Recommendation Report for Planning Permission for Works or Extension to a Dwelling

REF NO: AB/41/25/HH

LOCATION: 24 Stewards Rise
Arundel
BN18 9ER

PROPOSAL: Single storey side/rear extension with terrace/patio and conversion of loft to habitable use including installation of 1 No. rear dormer and front rooflights, following demolition of existing detached garage and lean-to.

Drawing Title
**Existing and Proposed
Section AA & BB**

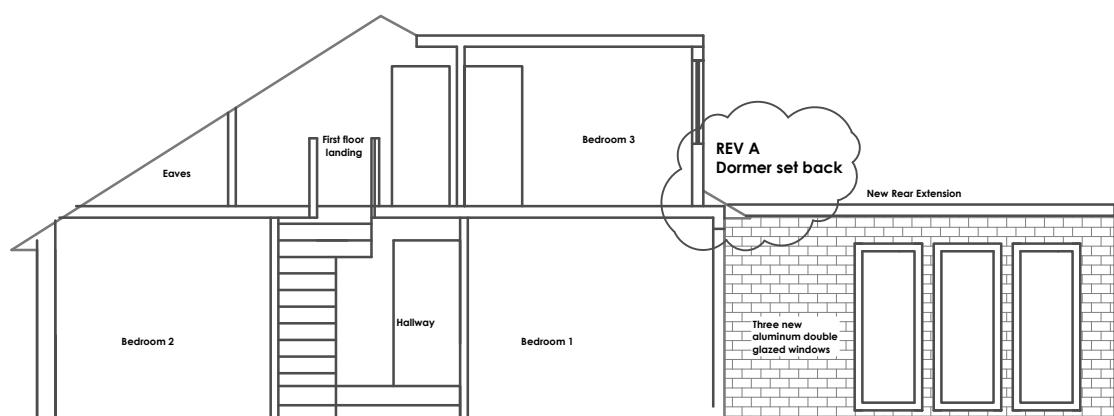
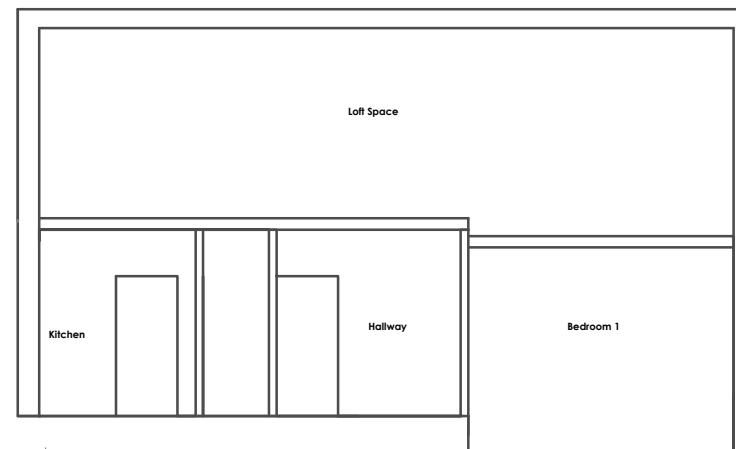
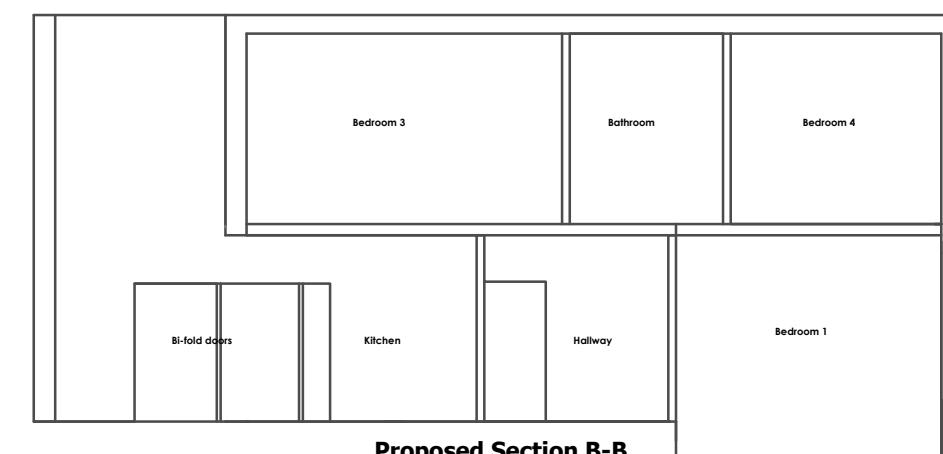
The proposed loft conversion will involve the addition of a dormer to the rear roof slope. The dormer is 9.8m wide and has a flat roof. This conflicts with the Arun Design Guide, which states that dormers should be minor incidents on the roof plane, and should incorporate pitched roofs in most cases. The dormer is set down from the ridge height and up from the eaves, however, the dormer does dominate the roof slope, in conflict with policy D DM4 of the Arun Local Plan. In this instance, it is noted that a similar rear dormer could be constructed under permitted development, and so a refusal on this basis would not be reasonable. The proposed material for the dormer is light grey composite cladding. This material is not currently present on the dwelling, but is proposed to the rear, and will not be unduly harmful.

The proposed rear dormer is situated within the roof slope and will not have any significant overbearing or overshadowing effects. The dormer introduces windows on the rear elevation at first floor level, which may result in increased overlooking. However, it is likely that a similar dormer could be achieved under permitted development. Overlooking impacts will not be unduly severe and would not warrant a refusal of planning permission. The proposed rooflights within the front roof slope would be separated from the neighbouring properties opposite the application site by the highway, and would not result in any overlooking.
